**WELWYN HATFIELD BOROUGH COUNCIL  
EXECUTIVE DIRECTOR - PLANNING, PUBLIC PROTECTION AND GOVERNANCE**

**Application No:** 6/2021/3155/HOUSE  
**Location:** 17 Great Braitch Lane Hatfield AL10 9FD  
**Proposal:** Conversion of loft to habitable use including 1 x rear dormer with Juliette balcony and insertion of 1 x side facing window to existing gable end.  
**Officer:** Ms Ashley Ransome

**Recommendation:** Refused

Drawing No: 5407-P01

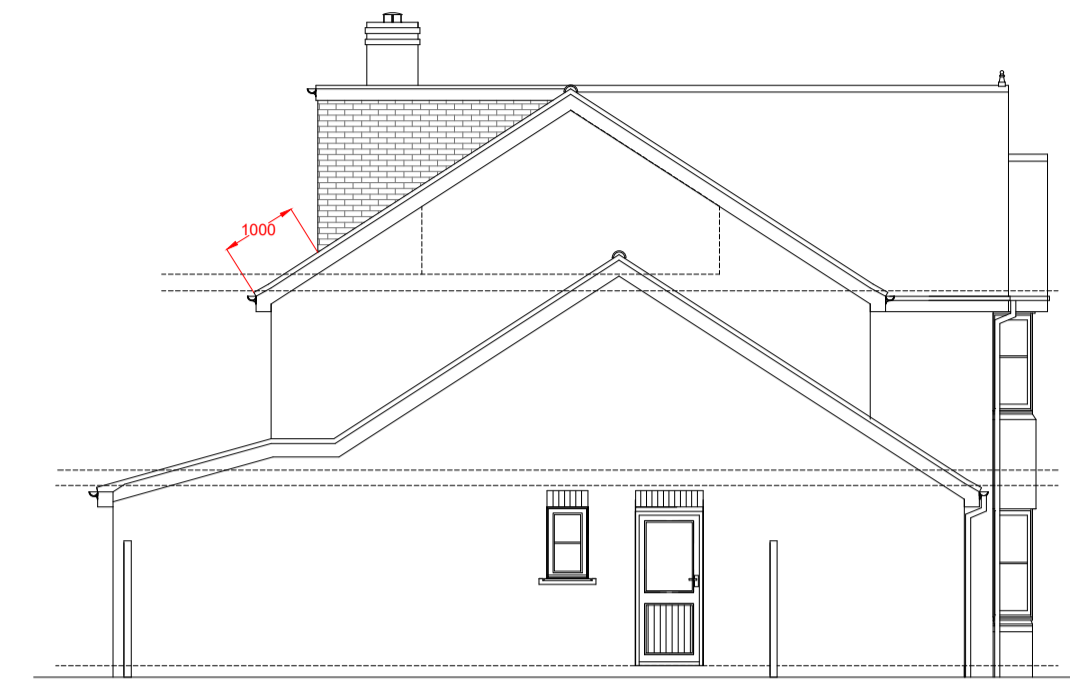
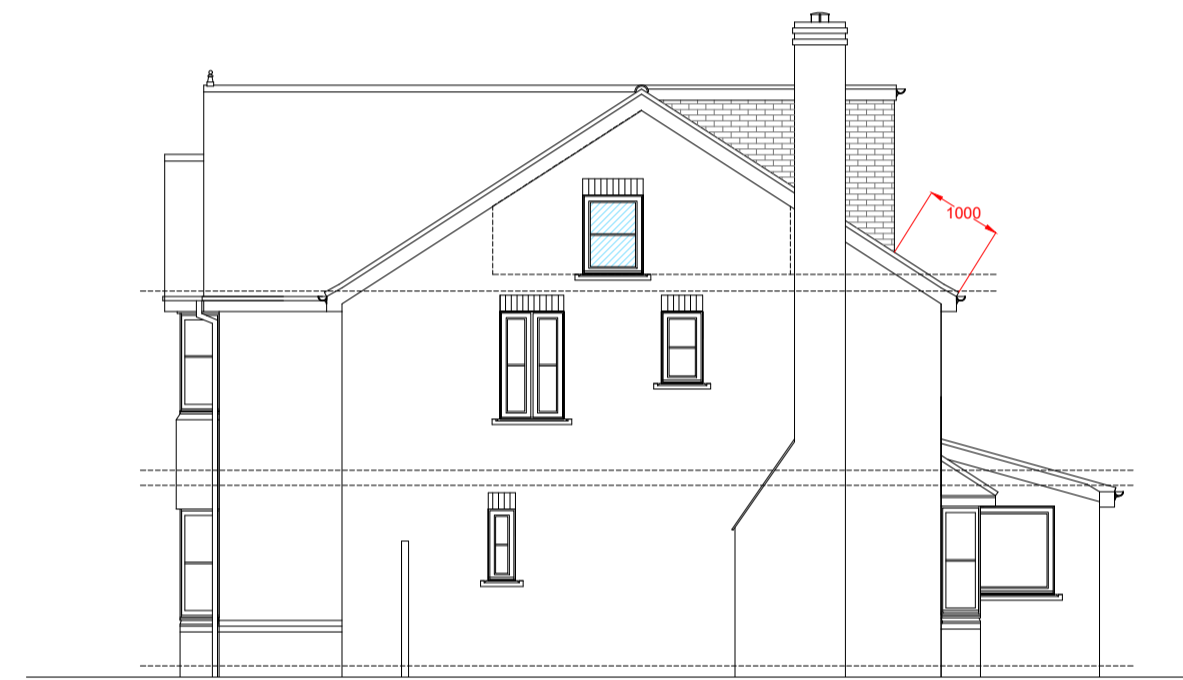
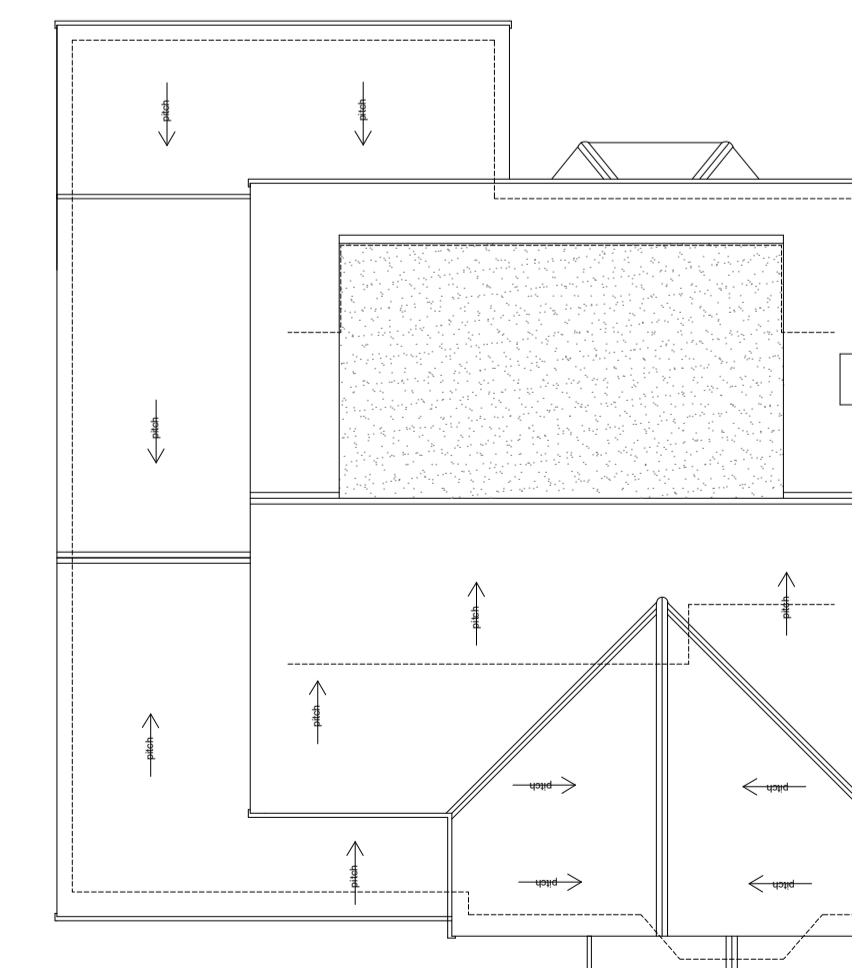
<p>property or of the party wall with the adjoining property.’</p> <p>The proposed rear dormer does not comply with the above as it is not considered to be of modest proportions and limited extent so as to not dominant the existing roof slope, thus it is therefore considered unacceptable. Moreover, the property does not benefit from Permitted Development Rights for such a proposal as these were removed through the granting of permission for the development of this site under reference S6/1999/0971/FP.</p> <p>As a consequence of the above, it is considered that the proposed development would not reflect the character and appearance of the surrounding area and it would have a harmful impact upon the character of the dwelling. Accordingly, it is considered that the proposed development represents a poor standard of design and is therefore contrary to Policies D1 and D2 of the Welwyn Hatfield District Plan 2005, Policy SP9 of the Welwyn Hatfield Draft Local Plan 2016, the Welwyn Hatfield Supplementary Design Guidance 2005 and the National Planning Policy Framework 2021.</p>

<p><b>Impact on neighbours</b></p>	<p>The impact of the proposed development on the residential amenity of neighbouring dwellings is considered in terms of the impact on neighbouring properties access to day/sun/sky light, privacy, overbearing and overshadowing. Policy D1 of the District Plan seeks to provide a good standard of design in all new development. The Council’s SPD on design supplements Policy D1 outlining that residential applications for extensions and alterations should not cause loss of light or be unduly dominant from adjoining properties, as a result of either the depth of the projection, the height or proximity of the extension.</p> <p>No neighbour representations have been received.</p> <p>It is considered that the size, scale, siting and design of the proposed development would have minimal impact on the residential amenity of the surrounding neighbouring properties and is considered acceptable and is in accordance with Policy D1 of the Welwyn Hatfield District Plan, Policy SADM11 of the Welwyn Hatfield Draft Local Plan 2016, the Welwyn Hatfield Supplementary Design Guidance 2005 and the National Planning Policy Framework 2021. Upon any grant of permission, a condition for the proposed flank elevation window to be obscure glazed would be imposed so as to maintain privacy to the neighbouring occupants at No.19.</p>

1. The proposed development, by virtue of its size, scale, design and layout, would fail to represent a subservient addition to that of the existing dwelling, not reflecting the local distinctiveness, to the detriment of the character and appearance of the existing dwelling and surrounding area. Accordingly, the proposed development represents a poor standard of design and is therefore contrary to Policies D1 and D2 of the Welwyn Hatfield District Plan 2005, Policy SP9 of the Welwyn Hatfield Draft Local Plan 2016, the Welwyn Hatfield Supplementary Design Guidance 2005 and the National Planning Policy Framework 2021.
